Comments for Planning Application 19/03203/CONDIT

Application Number: 19/03203/CONDIT

Address: 69 - 71 Church Road Anerley London Bromley SE19 2TA

Proposal: Details submitted to discharge condition in relation to planning ref:

PROPOSED SIDE ELEVATION  
SCALE 1:100

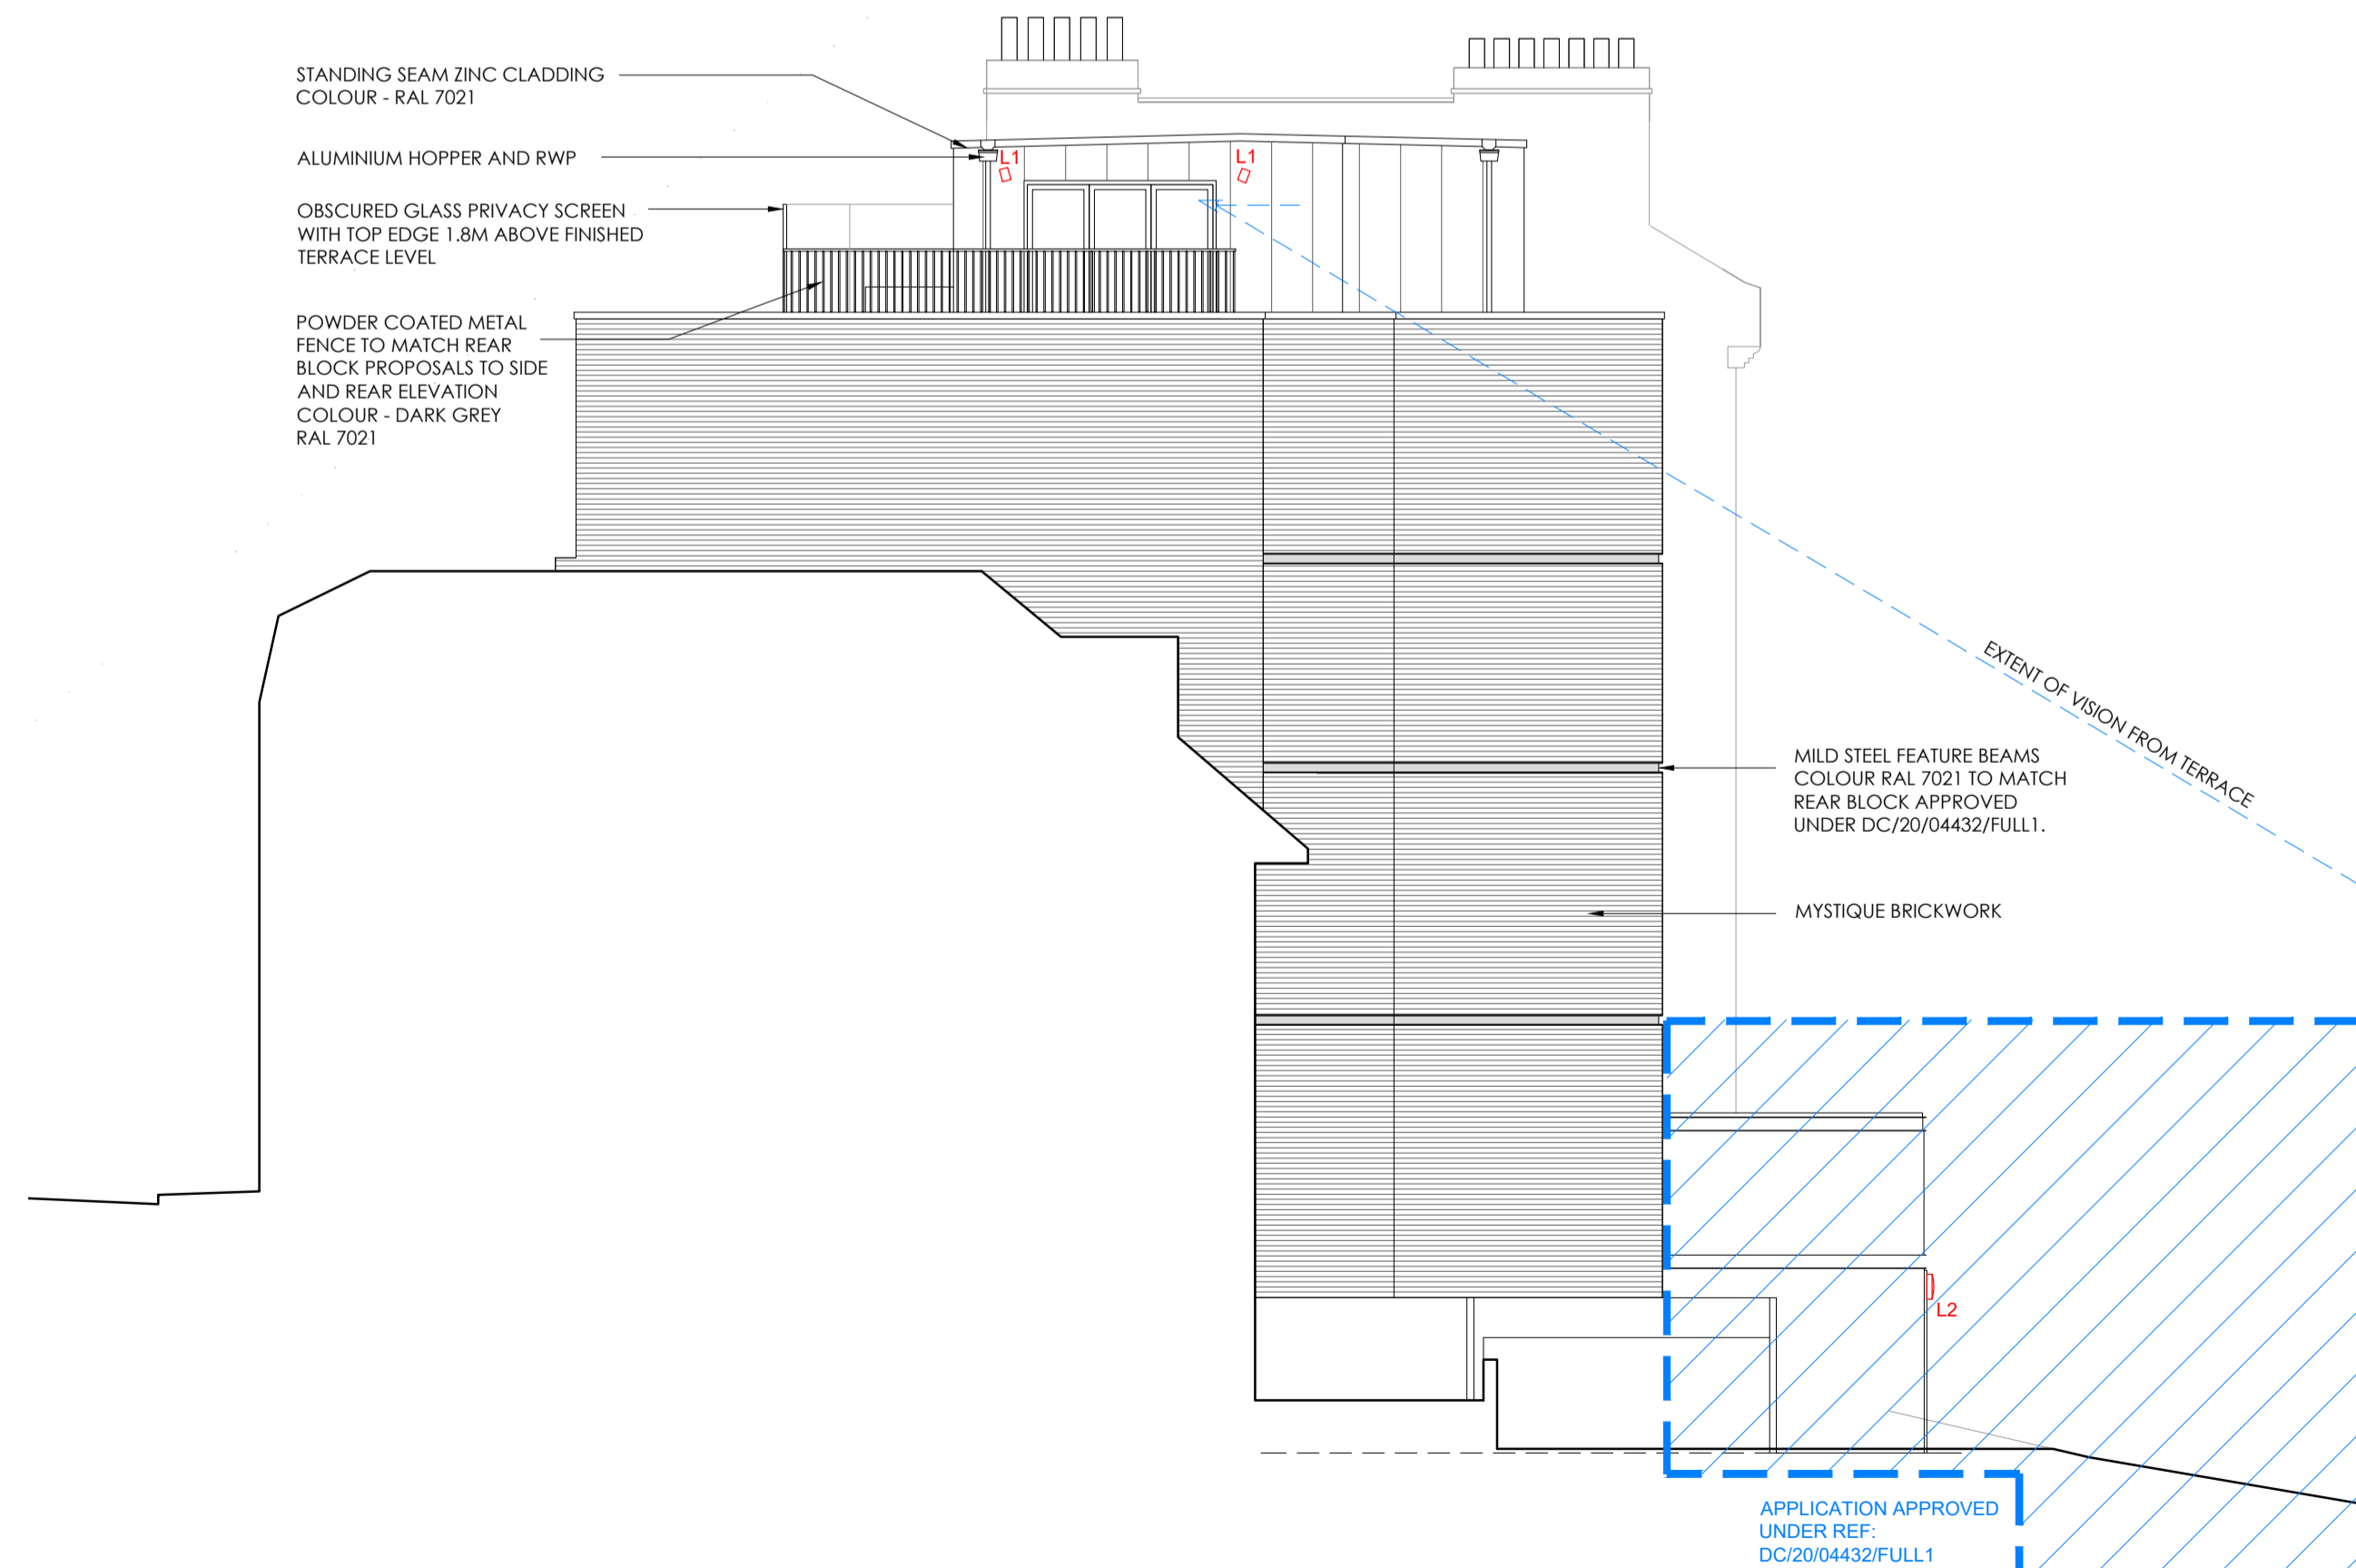
Comment: The roof top arrangements allows people to state into my daughter bedroom and my bathroom at 60 c church Rd. The the privacy screen should be raised to 2m above floor level. This will also protect the privacy of other adjacent neighbours.
